8 July 2022

**PHASE 1, LAND OFF ARUNDEL ROAD, ANGMERING BN16 4ET (APPLICATION REF. A/46/22/RES)
APPLICATION TO PARTIALLY DISCHARGE CONDITION 1 PURSUANT TO OUTLINE PLANNING
PERMISSION (APPLICATION REF. A/207/21/PL)**

We have set out below a response to the comments provided by Officers under cover of email dated 8th June 2022 (and discussed during our subsequent meeting) with regard to the submitted material.

CLIENT:	Redrow Homes	PROJECT:	Phase 1 - Arundel Road Angmering
SCALE:	1:100 (A3 ORIGINAL)	DRAWING:	Stratford Lifestyle - Plans & Elevations BRICK
DRAWN:	RDP		
DATE:	Feb 2022	20232	P415 B

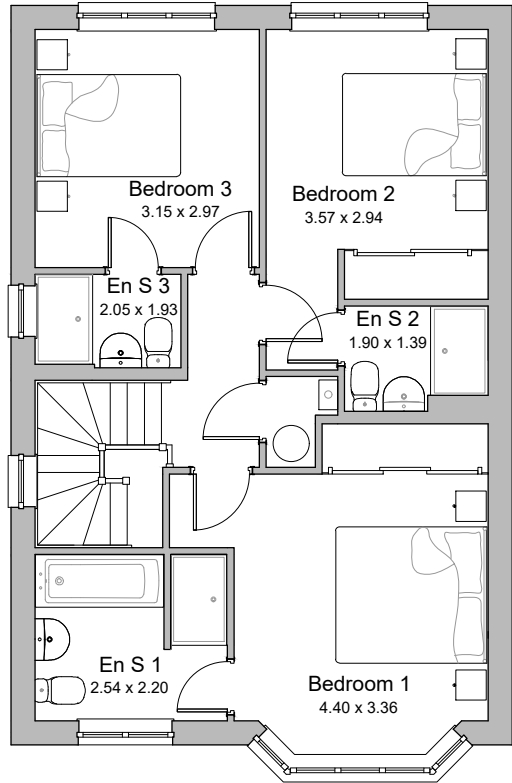
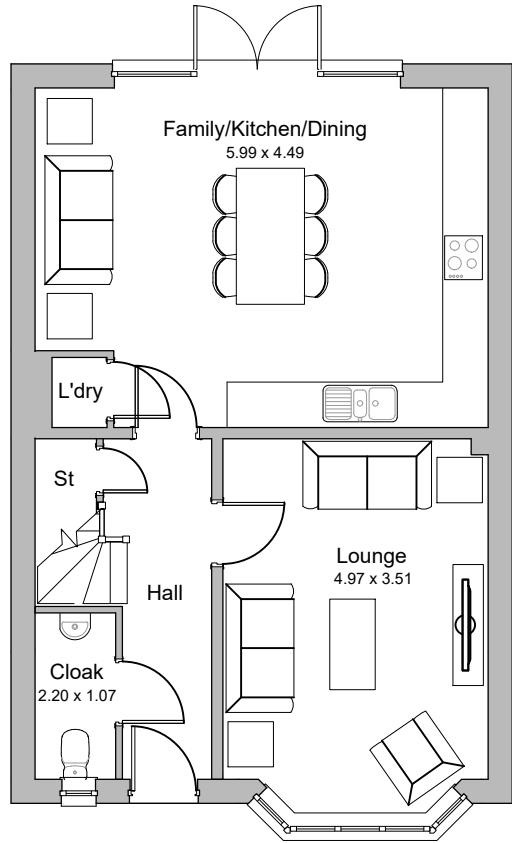
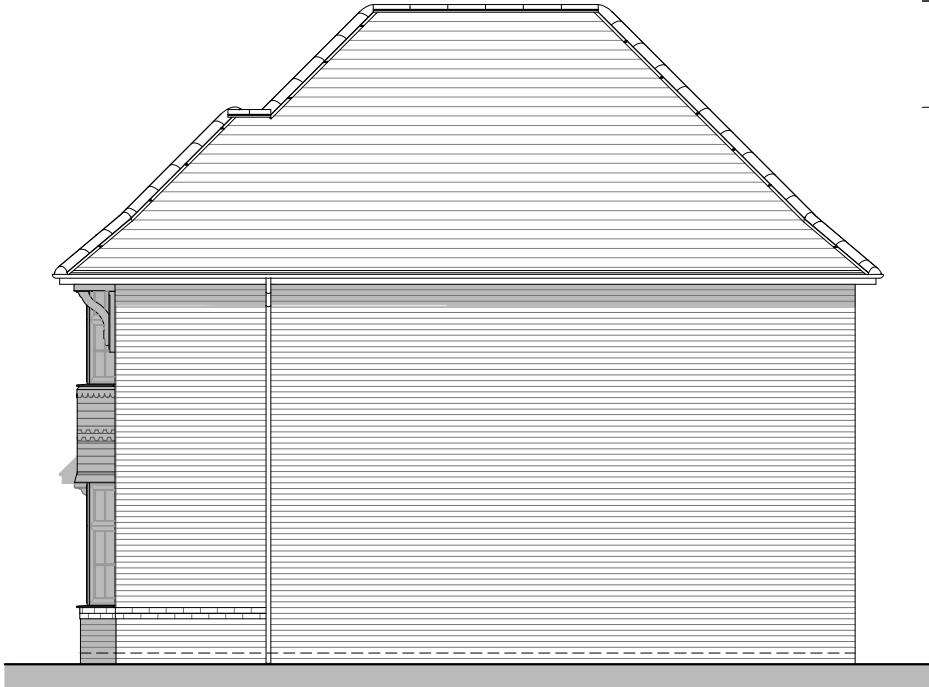
The Arun Design Guide sets out guidance on interface distances between houses. There are a several instances in the development layout where these standards are not met, as follows: – Plots 5 and 6 rear to plot 7 side is only 12m vs the 14m requirement – Plot 3 private rear garden is only 9.2m vs the 10.5m requirement	A plan has been provided on page 10 of the Design Code Compliance Document that demonstrates that the interface distances required within the Arun Design Guide have been secured for the proposed dwellings.
The Arun Design Guide sets out that private rear garden should be at least 10.5m deep and those front gardens provide a minimum of 2m defensible space. The layout does not meet these requirements in some instances, as illustrated in the “Coloured site layout plan- 20232 / C401A”. – Plot 6 private rear garden is only 9.8m vs the 10.5m requirement – Plot 5 private front garden is only 1.1m vs the 2m requirement	A plan has been provided on page 10 of the Design Code Compliance Document that demonstrates that the interface distances required within the Arun Design Guide have been secured for the proposed dwellings.

Client	Redrow
Job	Arundel Road, Angmering
Title	Site Layout

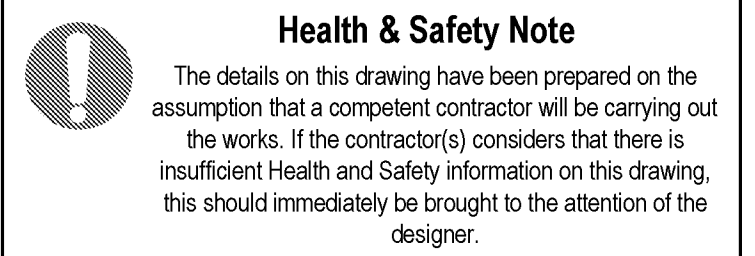
The comments set out a holding objection until sufficient information was provided in relation to SUDs and drainage system drawings, drainage calculations and the requirement for ordinary watercourse land drainage consent.

Turley Comment: We note that further information in relation to drainage was submitted on 6th June 2022 in order to address the comments raised. Redrow are continuing to engage directly with Paul McCann at Arun District Council to agree the drainage strategy.
